Town & Country Planning Act 1990 (as amended)
Town & country Planning (Development Management Procedure) (England) Order 2015
Application for Planning Permission for Works or Extension to a Dwelling

Development Construction of two storey extension & demolition of existing conservatory & outside WC.

Location 59 Elm Grove Barnham

SITE PLAN

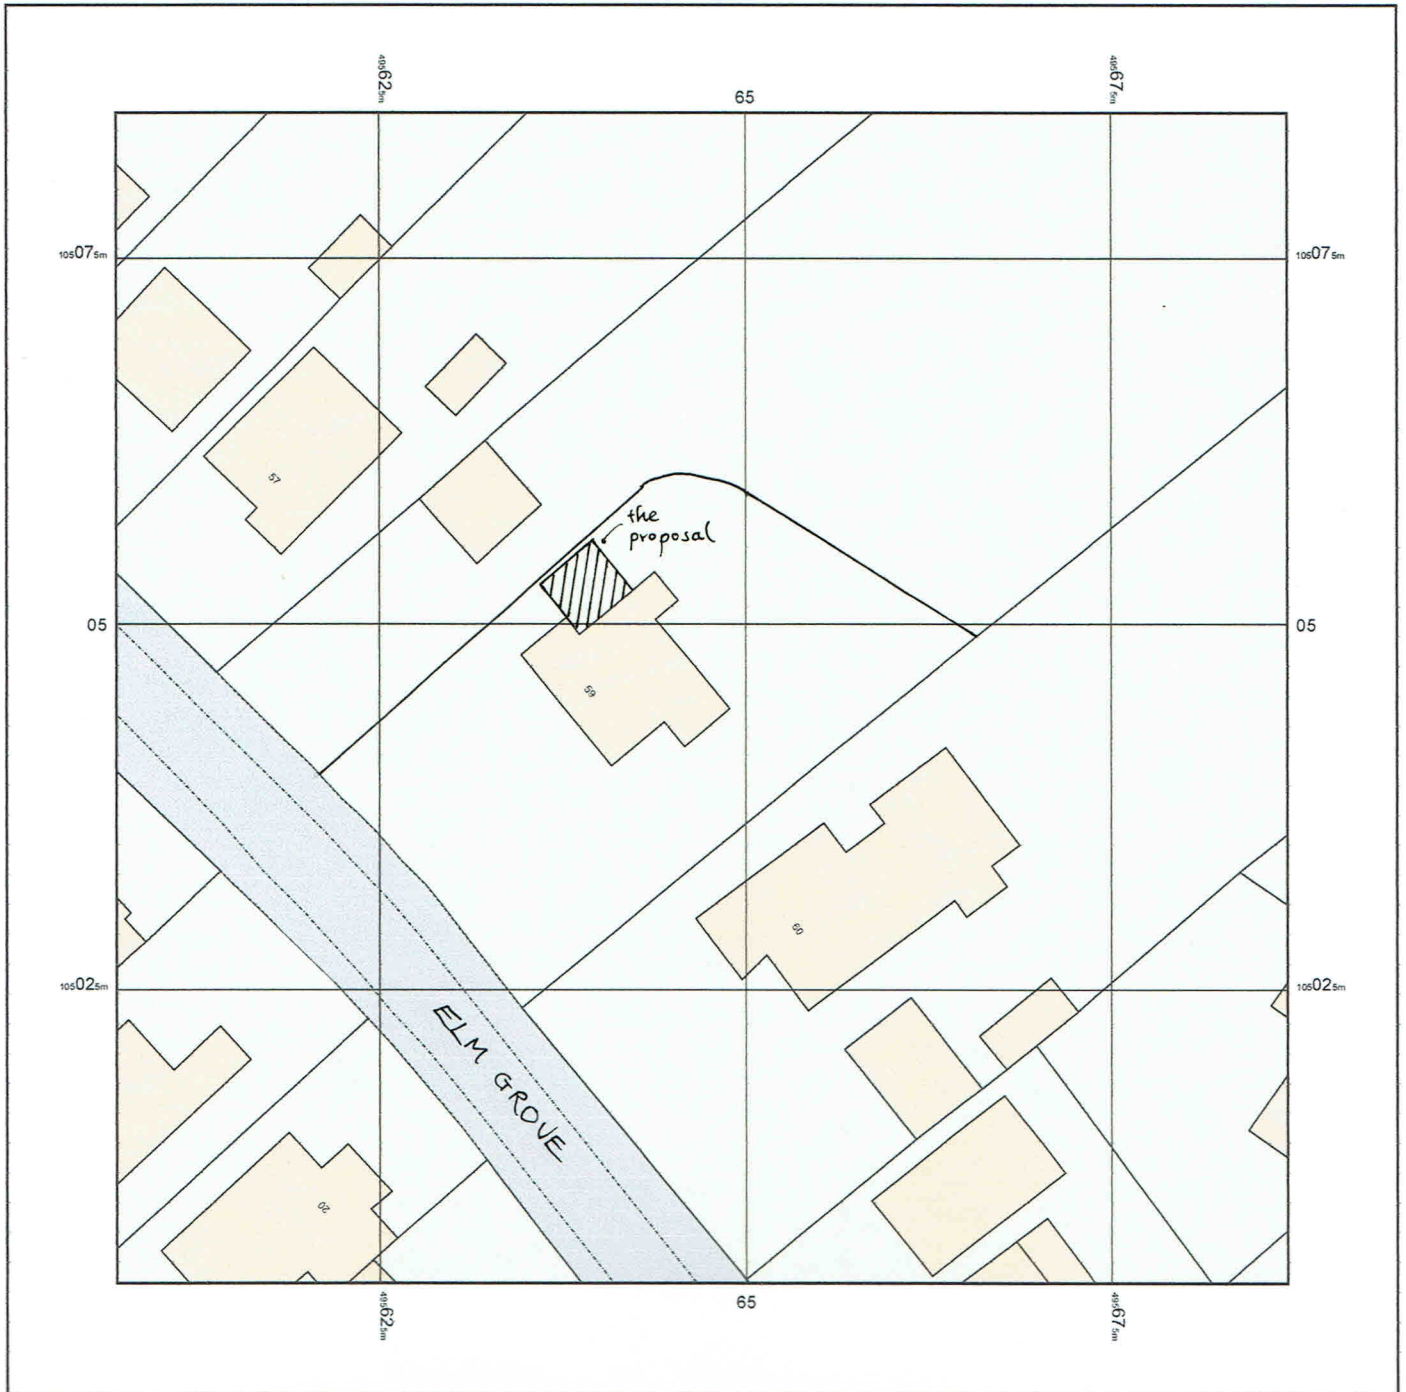
Block Plan

Please submit 1 electronic or 3 paper copies of an amended block/site plan at a scale of 1:500 or 1:200 showing the dimensions to the boundaries
